Consultation Response from KC, Lead Local Flood Authority		
2021/91506 Shop Lane, Kirkheaton, Huddersfield, HD5 0DB		
Reserved matters application pursuant to outline permission 2014/92535 for erection of 48 dwellings, formation of access and associated infrastructure		
Date Responded: 1st July 2021	Responding Officer: Paul Farndale	Responding Ref:

Kirklees Flood Management & Drainage as Lead Local Flood Authority requires further information for completeness of this application.

**Surface Water Network**

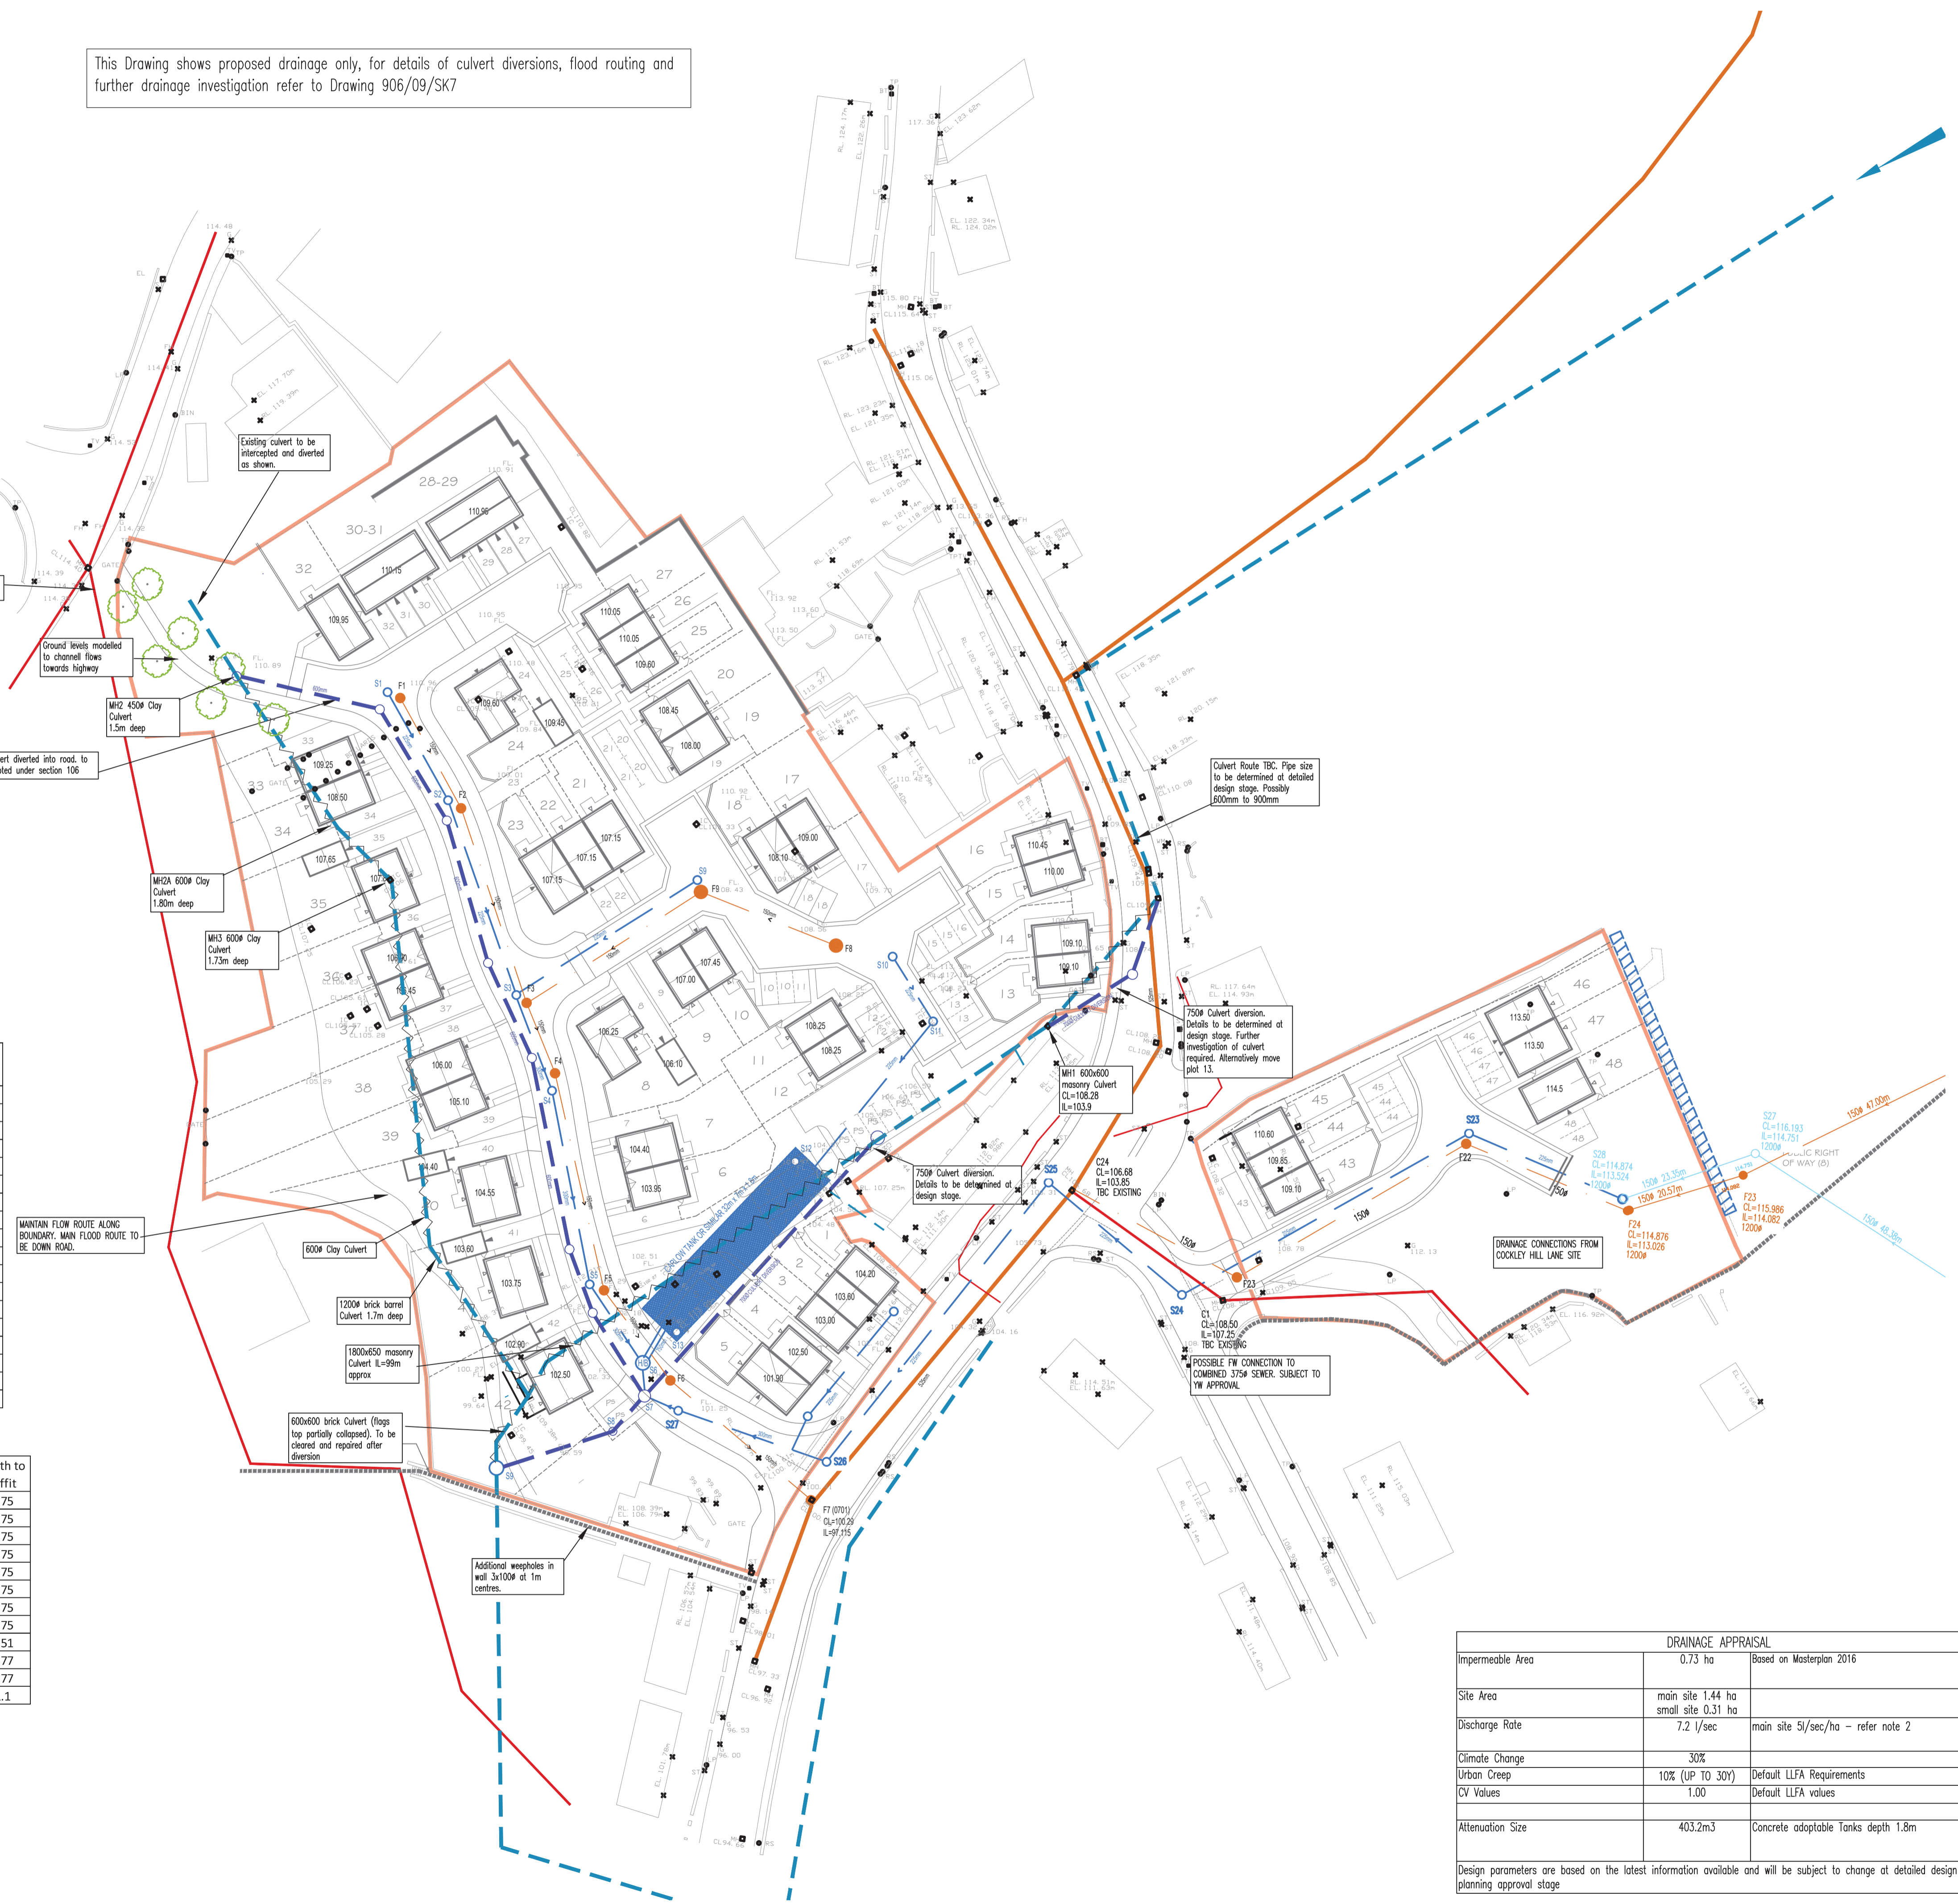
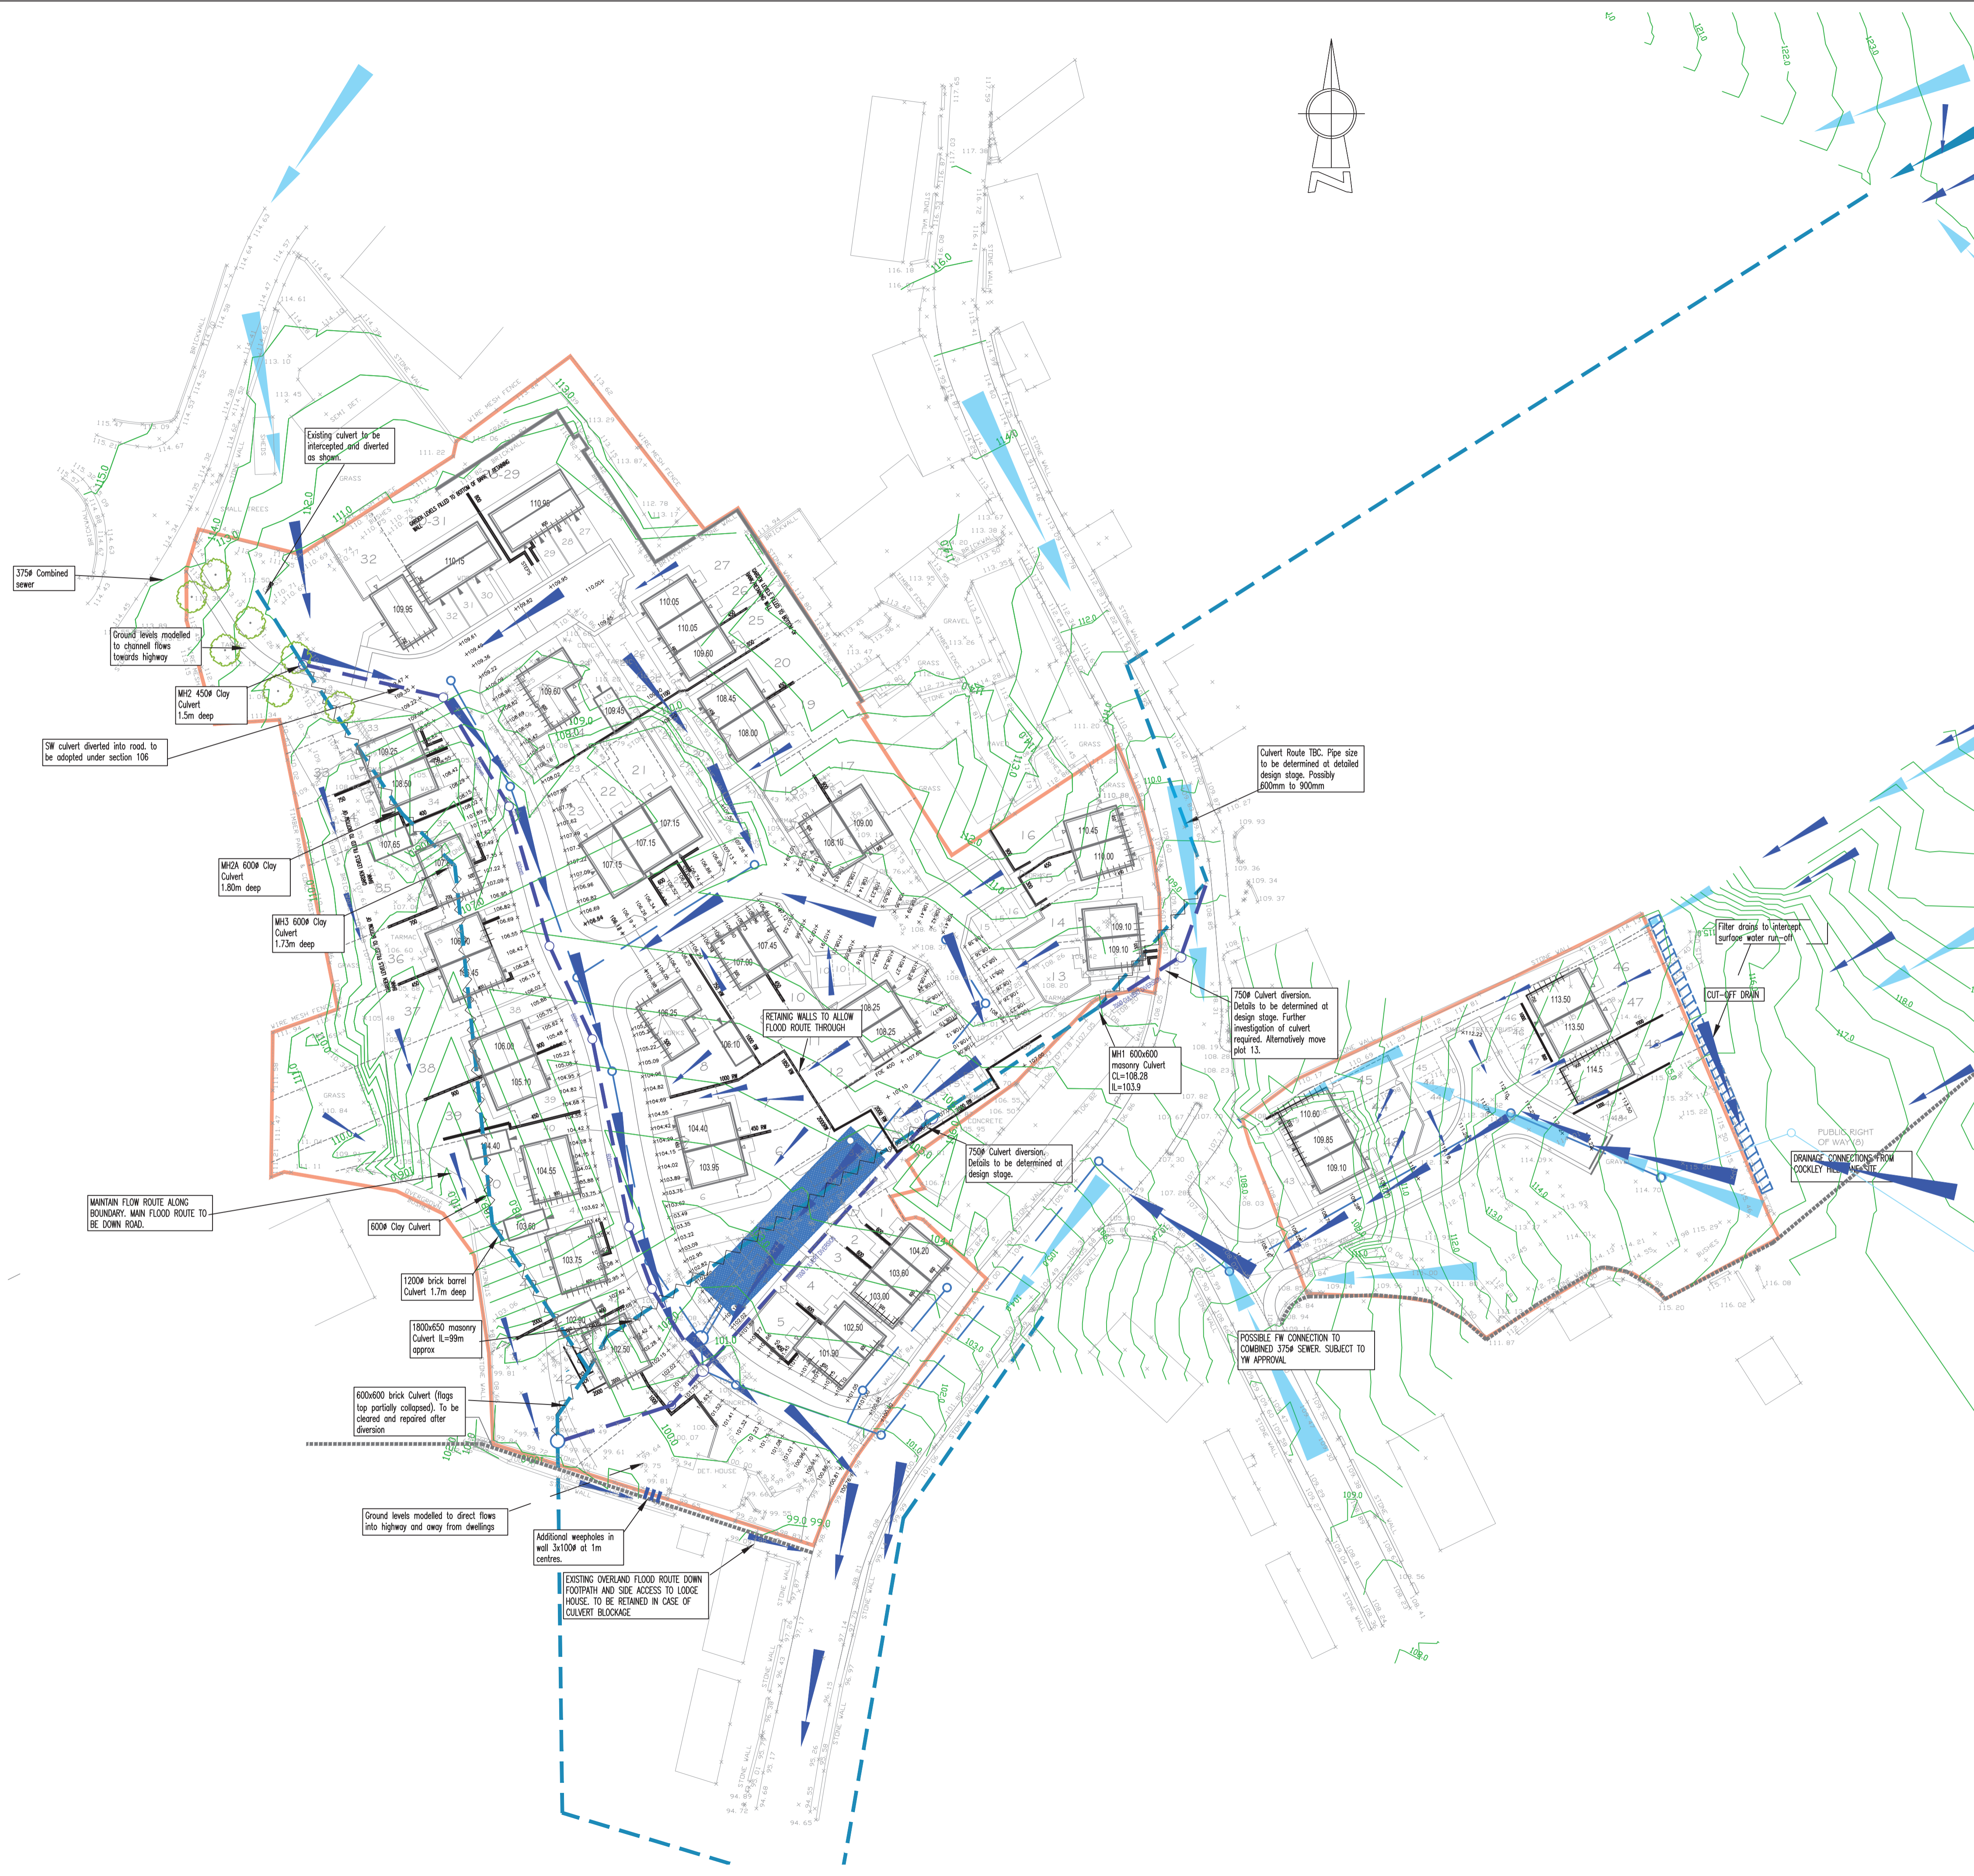
- **Microdrainage calculations for the surface water system to cross reference with the plan submitted.**

This is in order to show that the specific dimensions listed are sufficient to prevent flooding in all but extreme events in order to show that space has been made for water in the layout design.
